**Recommendation:** Refuse

**Proposal:** Extensions & alterations to existing house, including alterations to external appearance

PROPOSED ELEVATIONS, scale 1:100

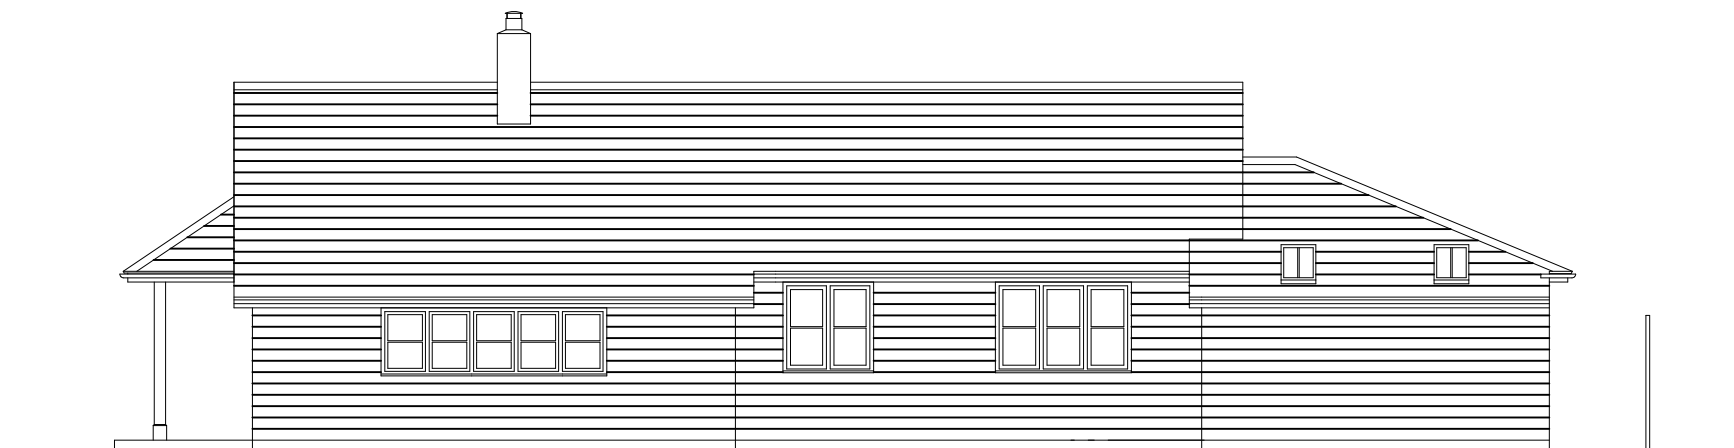
*There are, however, concerns with the building being constructed entirely of timber boarding which may look incongruous in relation to the surrounding area and detract from the listed building.*

The rear extension, which protrudes to the east, the east facing side extension and front extension would result in a significant change to the character of the existing dwelling and the immediate streetscene by way of the addition of incongruous features which would appear oppugnant to the simple nature of the existing dwelling. Further, I consider that these additions, particularly given the incongruous construction materials, would present demonstrable harm to the setting of the designated heritage asset.

I note that the predominant construction material of timber cladding is proposed. Whilst this material is in situ on the existing dwelling as a minor detail, the use of the material as the predominant construction material would appear incongruous and out-of-keeping with regards to the character of the existing dwelling and immediate streetscene. Furthermore, the use of timber cladding runs contrary to the Cherwell Residential Design Guide (2018) and is considered to result in some harm to the setting of the adjacent Grade II listed building.

The proposed rear extension would be situated approximately 9m from Red Brick Cottage and would not breach the 45-degree line. Three windows would be added to the side elevation of the rear extension; however, given the existing fenestration in this elevation, I do not consider that the proposals would result in any additional impact to this neighbour as a result of these openings.

EXISTING & PROPOSED ROOF PLANS, scale 1:100

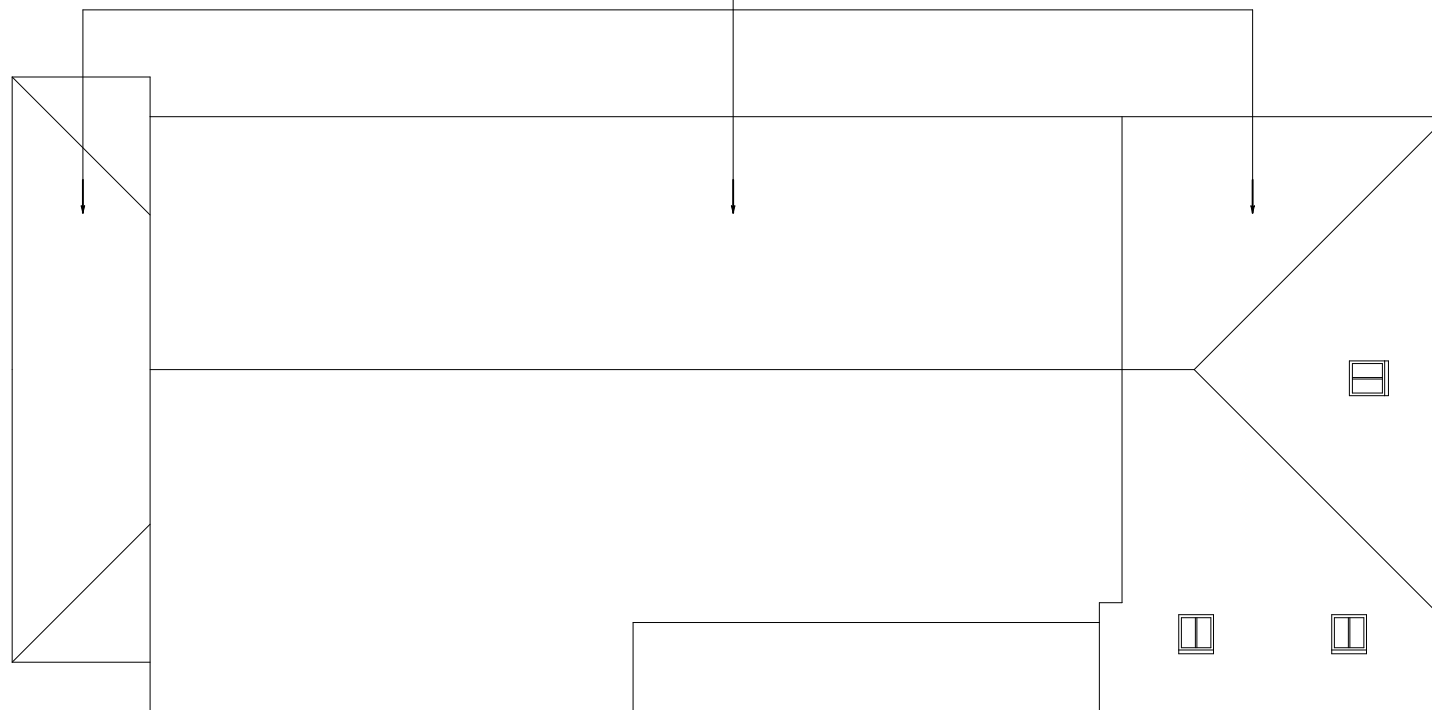
One rooflight would be positioned to the rear of the extension facing north and two would be positioned to in the side of the rear extension to face east; however, these would be at single storey level, would thus direct sight upwards and so would not result in a loss of privacy or additional overlooking of neighbouring properties.
